RE: **Tierra Vista Unit 3** (Replat of Tract 8, The Trails, Unit 2) File: **C09-D001E**
Grading & Drainage Plan for Preliminary Plat, Site Plan, and Grading Permit
PE Stamp: **3-20-2014**

Based upon the information provided in your submittal received 3/21/14, the subject Grading and Drainage Plan cannot be approved for DRB action on the Preliminary Plat nor Grading Permit. Please address the following items and resubmit for approval:

April 17, 2014
File: **C09-D001E**
Grading and Drainage Plan
Tierra Vista Unit 3 (Replat of Tract 8 of The Trails, Unit 2)

DOUBLE "A" INLET DETAIL
NOT TO SCALE

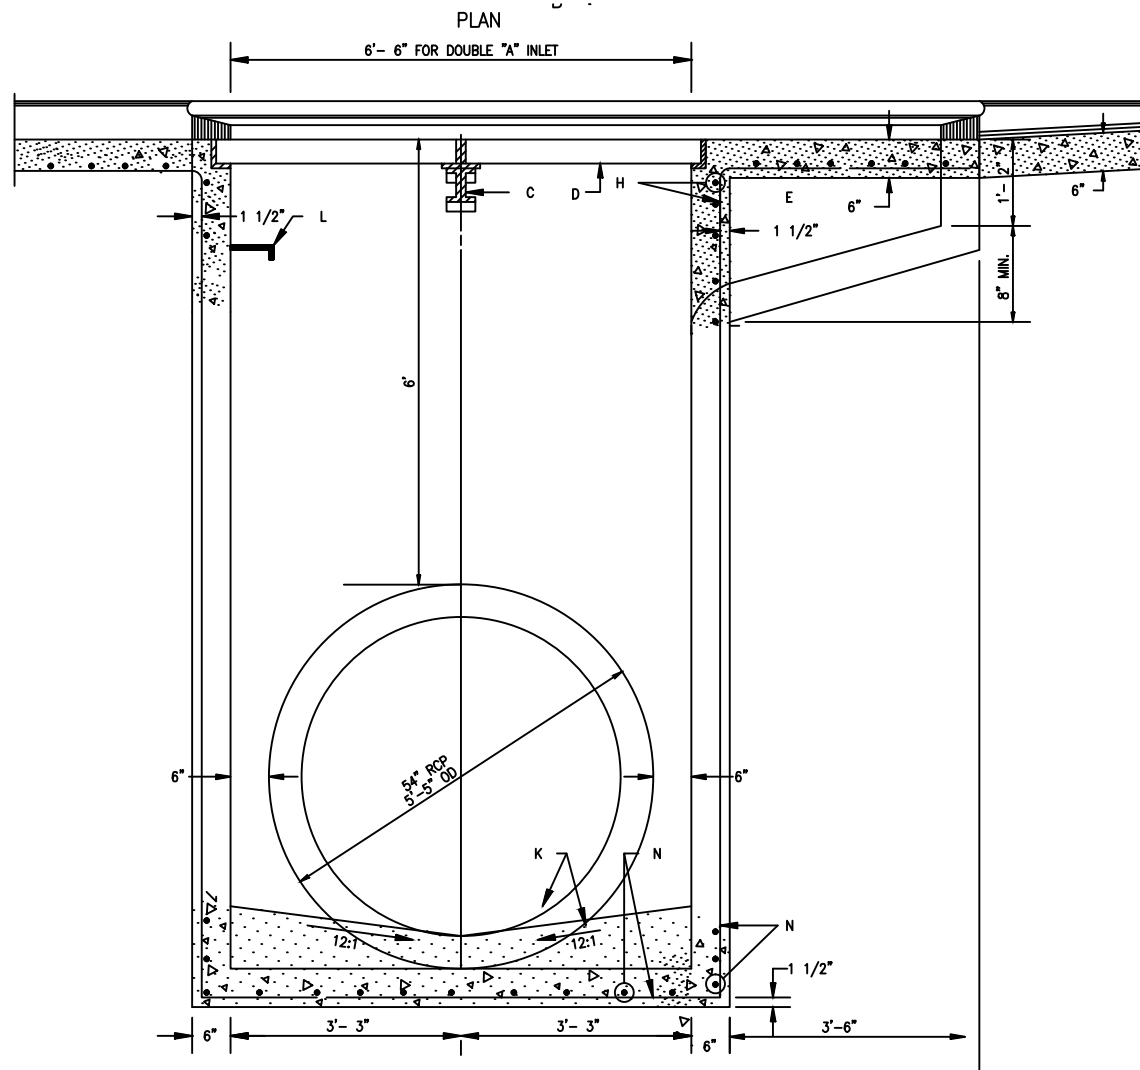
- b. Construct 54" Storm Drain in Tempe, from west side of Universe to Camp Verde, including Double Type-A Inlet at the east end of Tempe
 - c. Construct modifications to the Pond H Inlet and Outlet (west end of Tempe), per the April 2014 Amended DMP for The Trails, Units 1-3.

**TIERRA VISTA UNIT 3 at the TRAILS**  
GRADING AND DRAINAGE PLAN

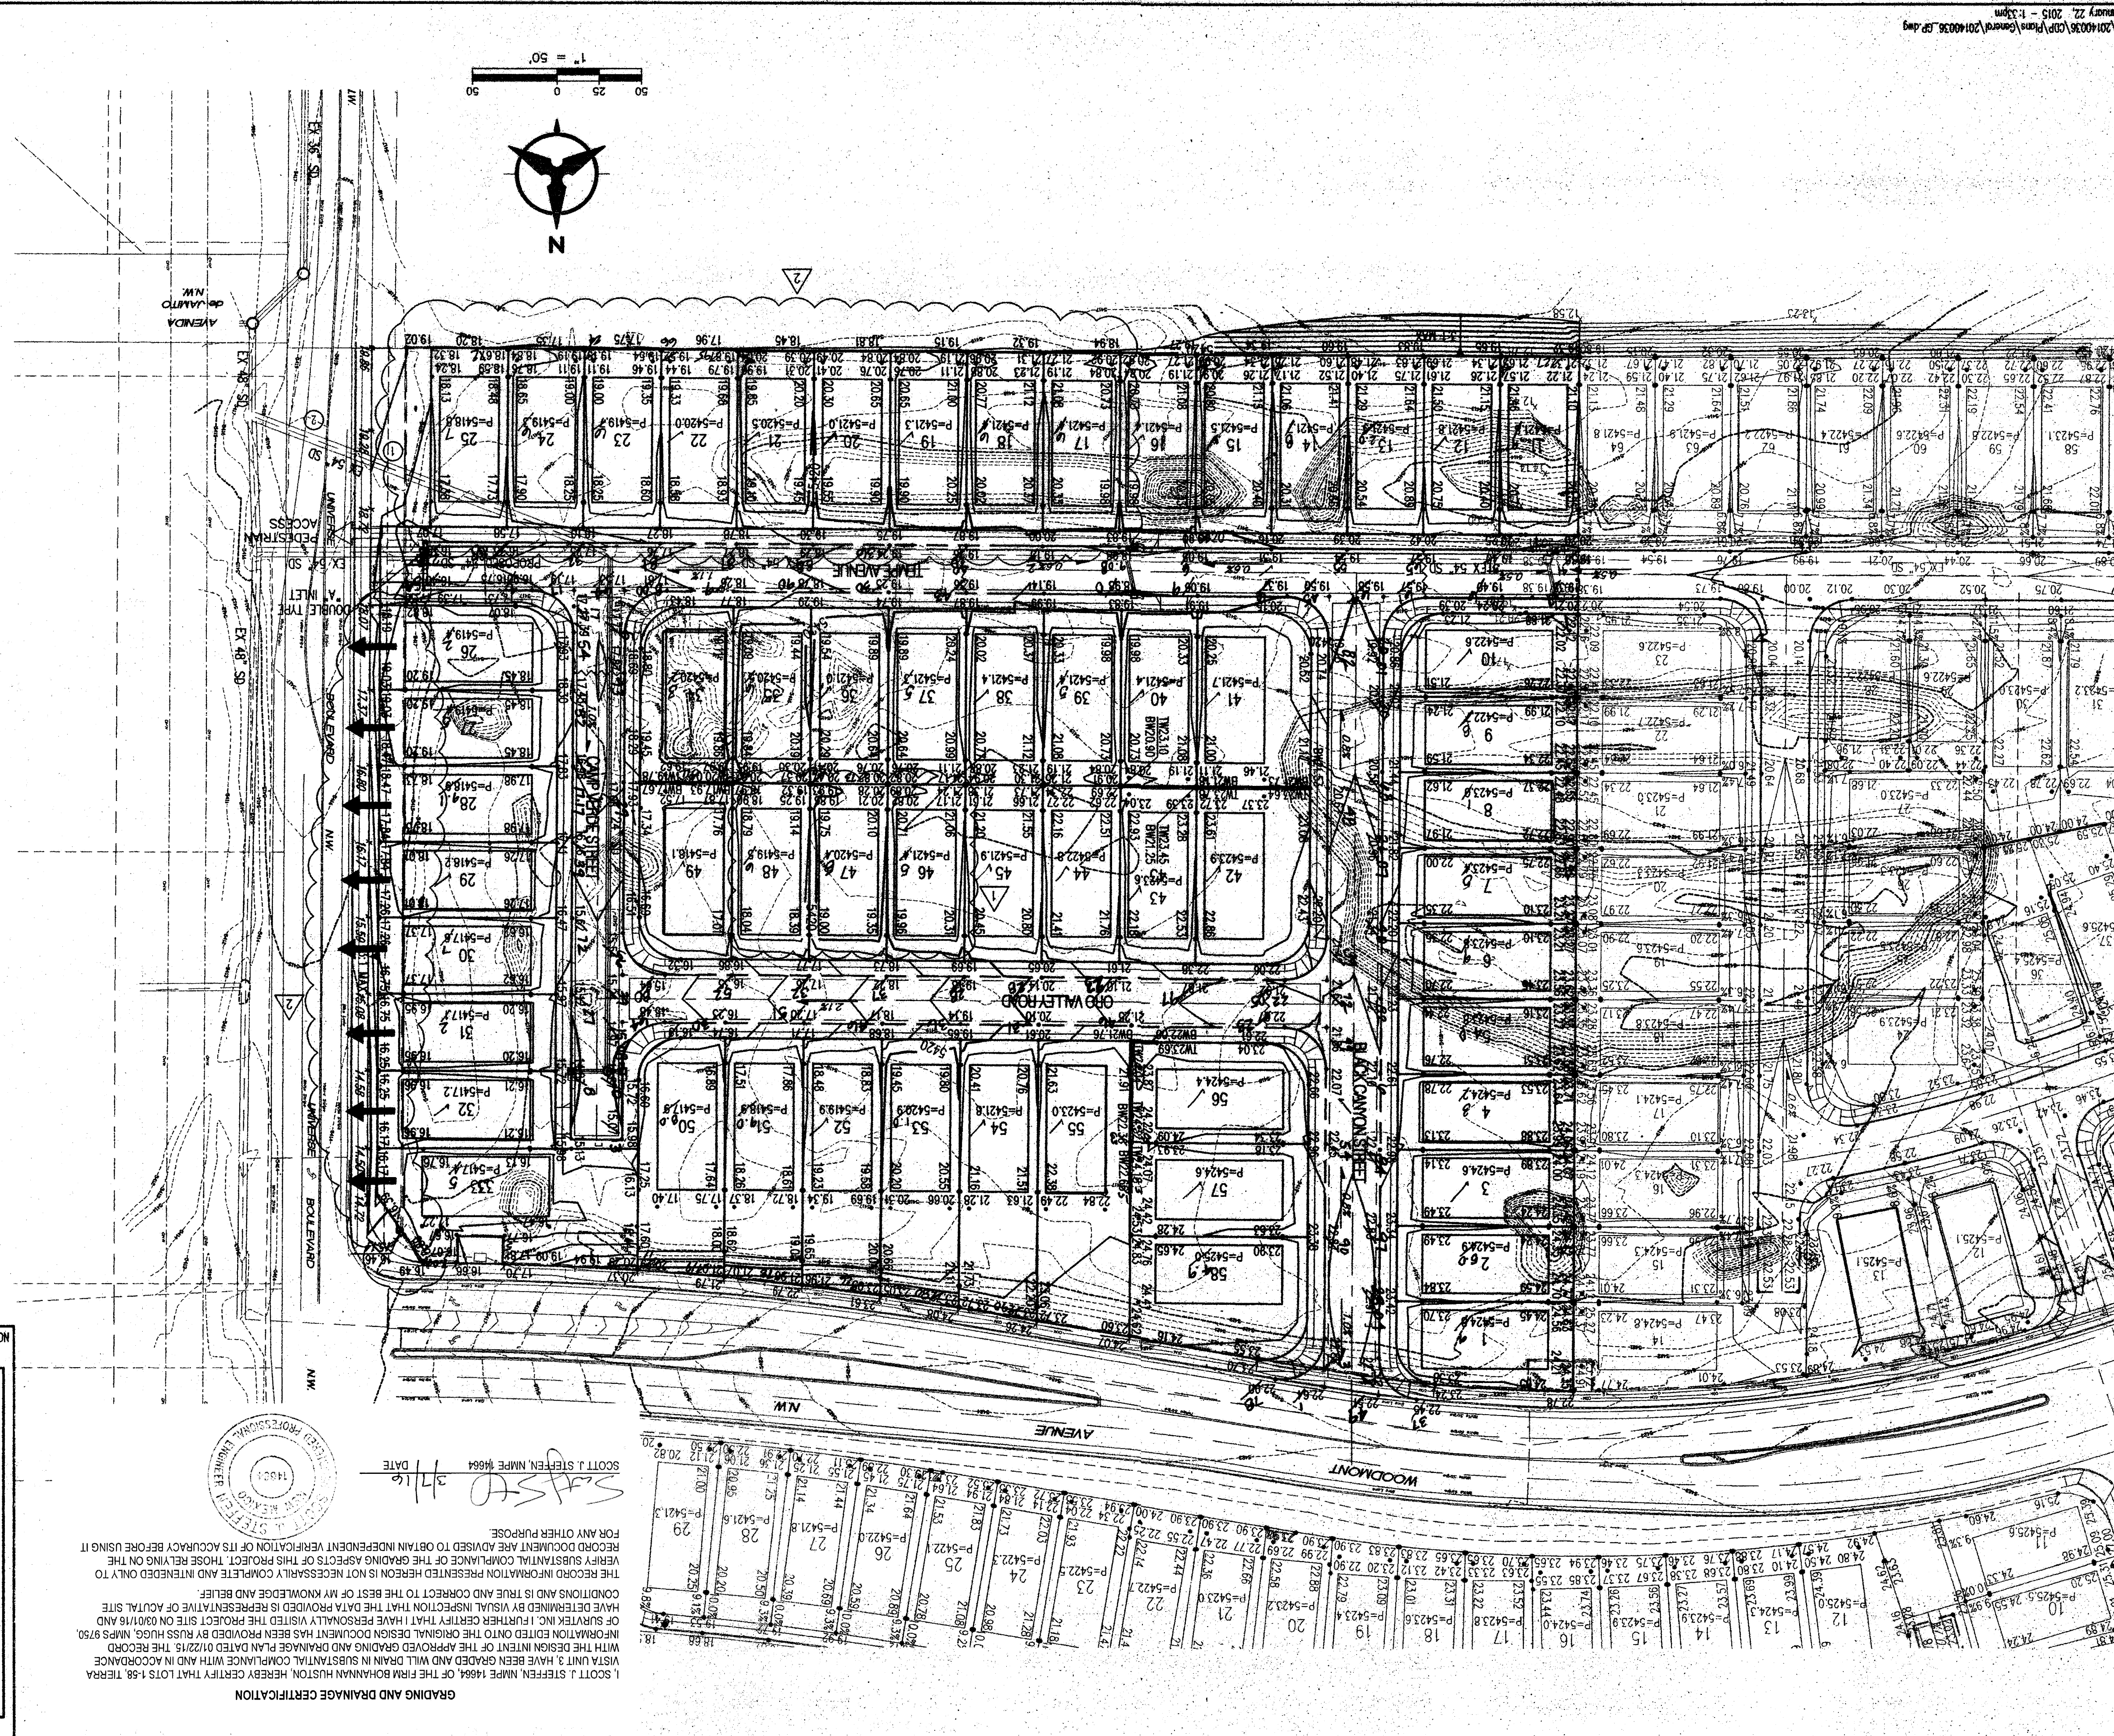
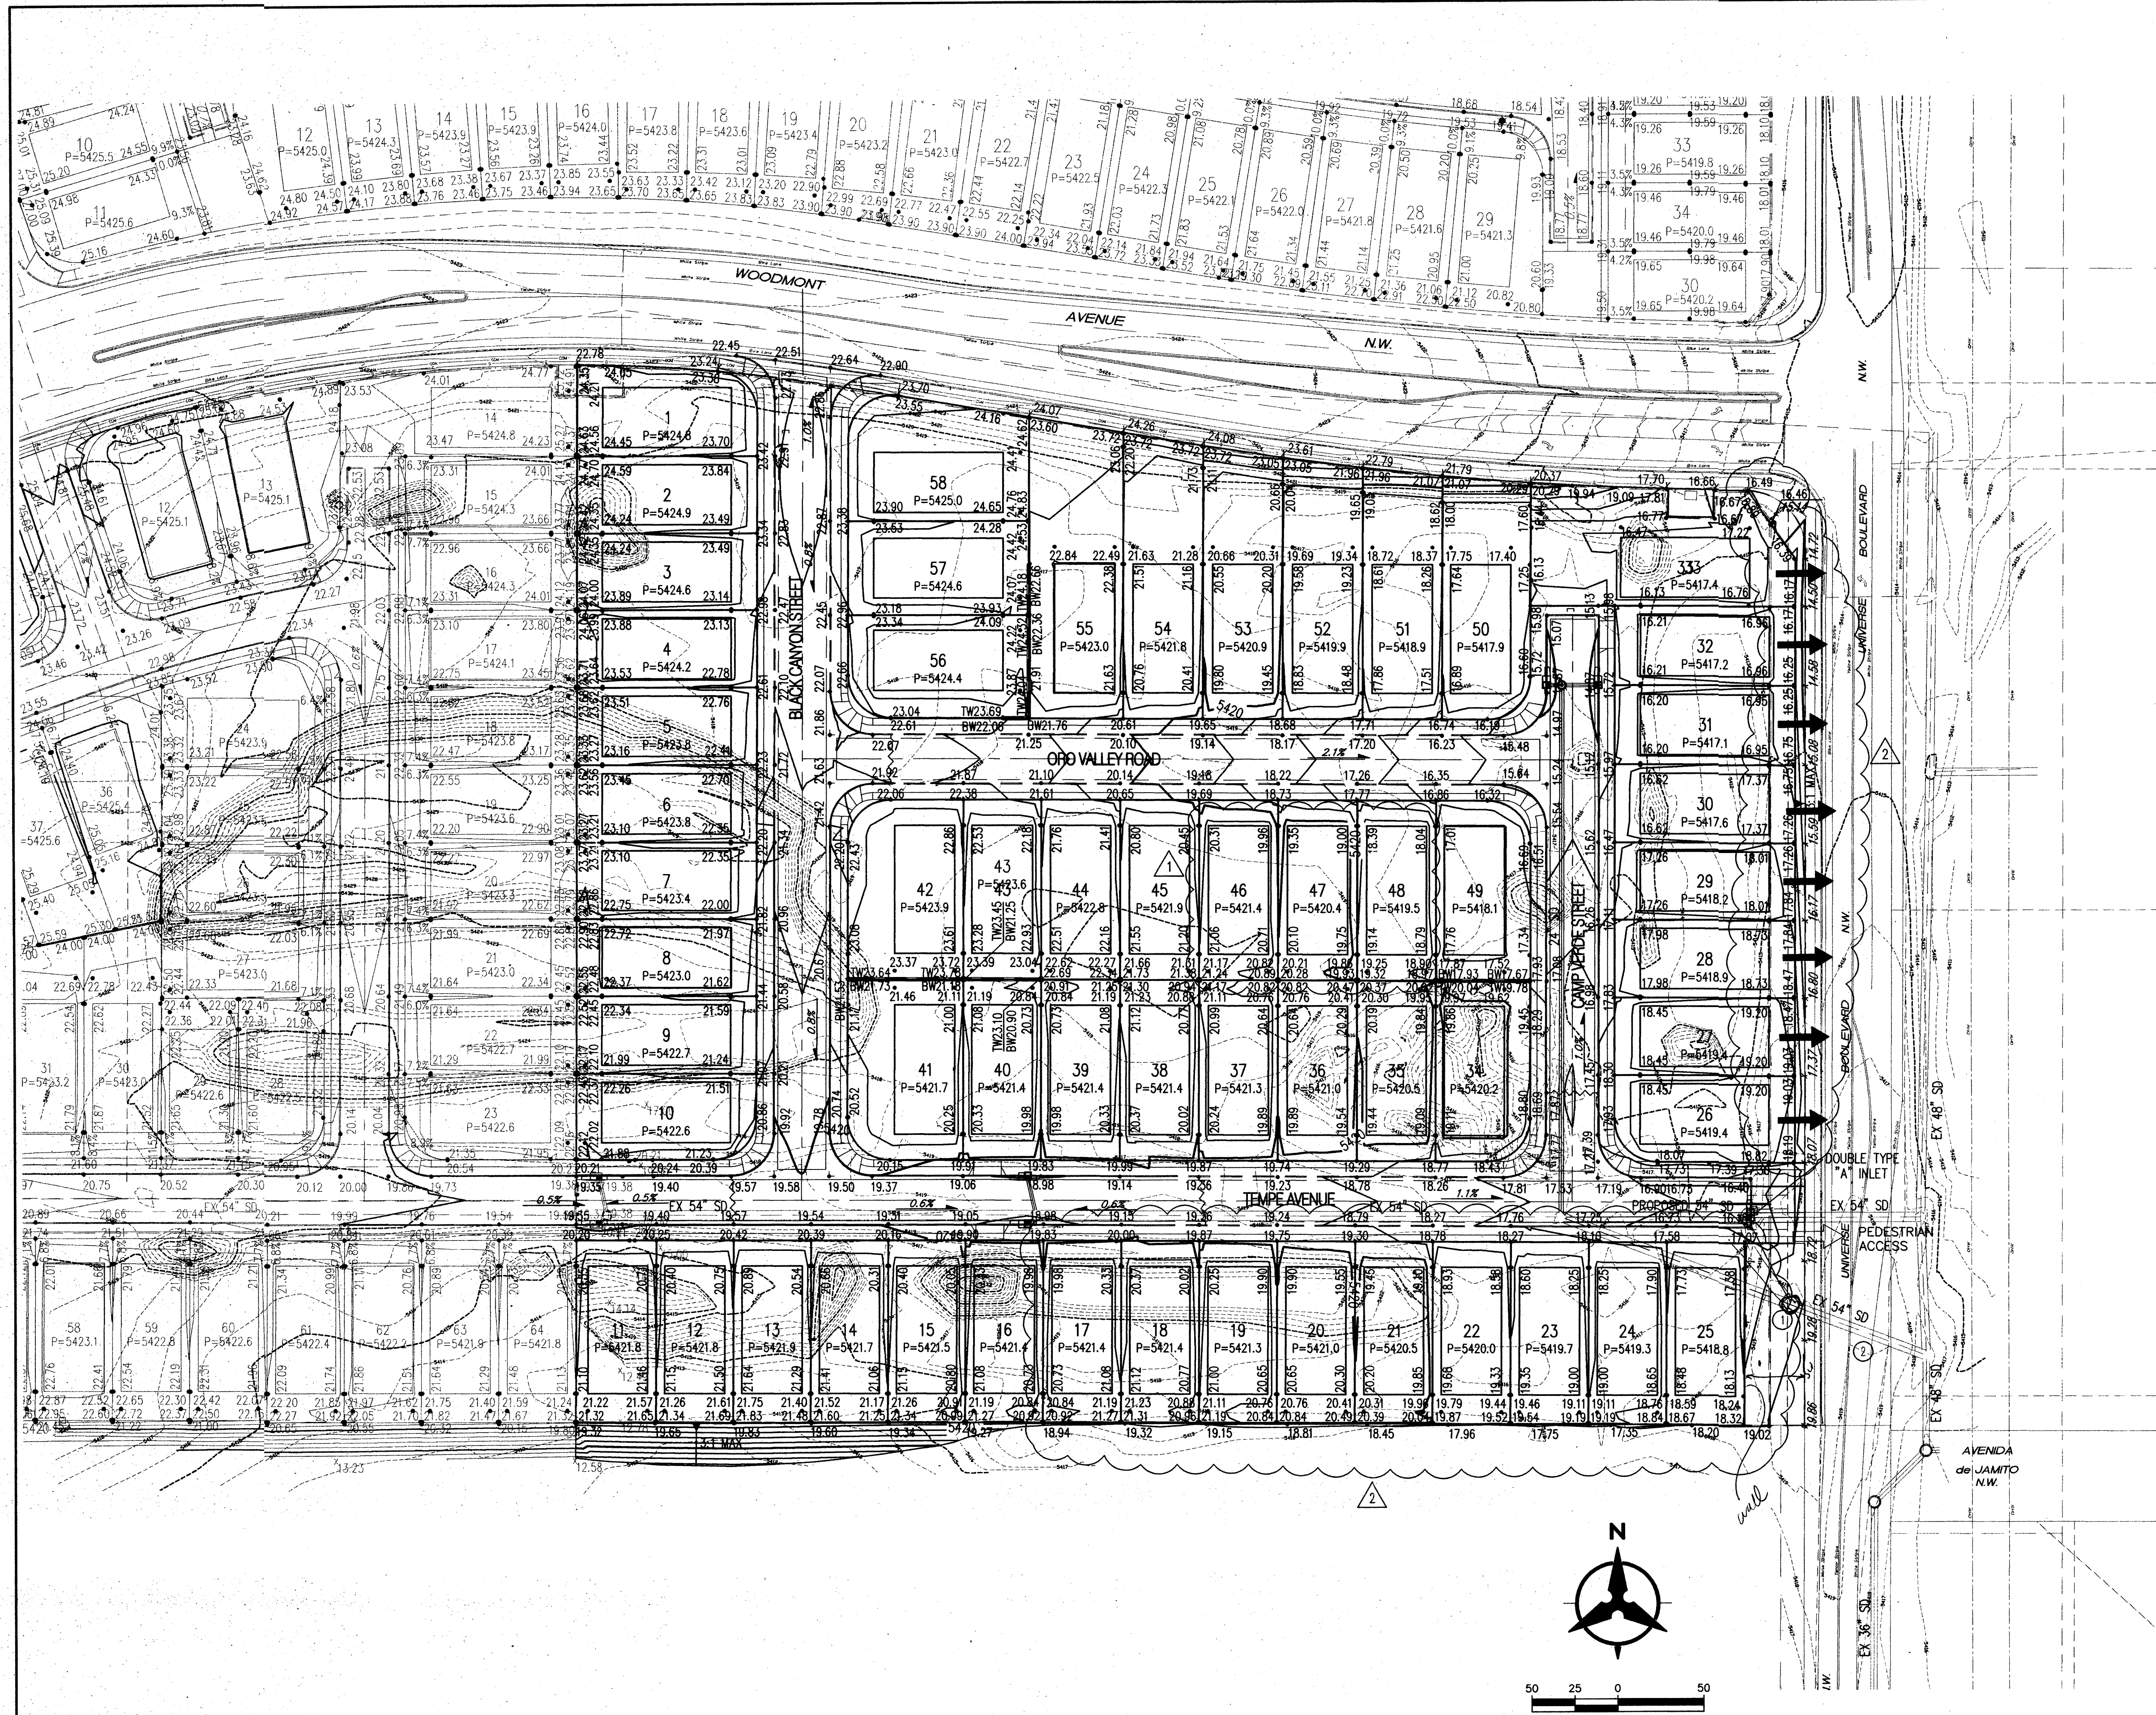
1. The plan shows offsite, slope grading along the south side of the site. Platting and grading approvals will require documentation of approval and/or grant of easement from the adjacent landowner.

3. Show grade break lines on the legend, and on the Grading Plan where basin the boundaries cross the roads. Confirm that they match the basin map. (Check the location of the K-2.B to K-2.D line crossing Tempe).

4. Label the Pedestrian Access way at the east end of Tempe, which serves as an emergency overflow to Universe.

5. The grades along Tempe ~~shown~~ show the K-2.D basin boundary at Camp Verde to be the north edge of the valley gutter, which could overflow to Basin K-2.C, which has not emergency outfall. Provide a more defined water block on Camp Verde.

6. On the grading plan, clarify the existing and proposed segments of 54" Storm Drain. Label the existing (skewed) 54" RCP to be removed from the MH at Tempe and Camp Verde to the back of curb on the west side of Universe. The portion under Universe pavement to the manhole in Universe may be left in place, if plugged and grouted full with lean fill.

7. At the NE corner of the site, this plan shows a retaining wall in an area where there is an existing 4' to 6' CMU wall and "The Trails" decorative wall panel. Will these walls need to be removed and rebuilt to retain the required heights?
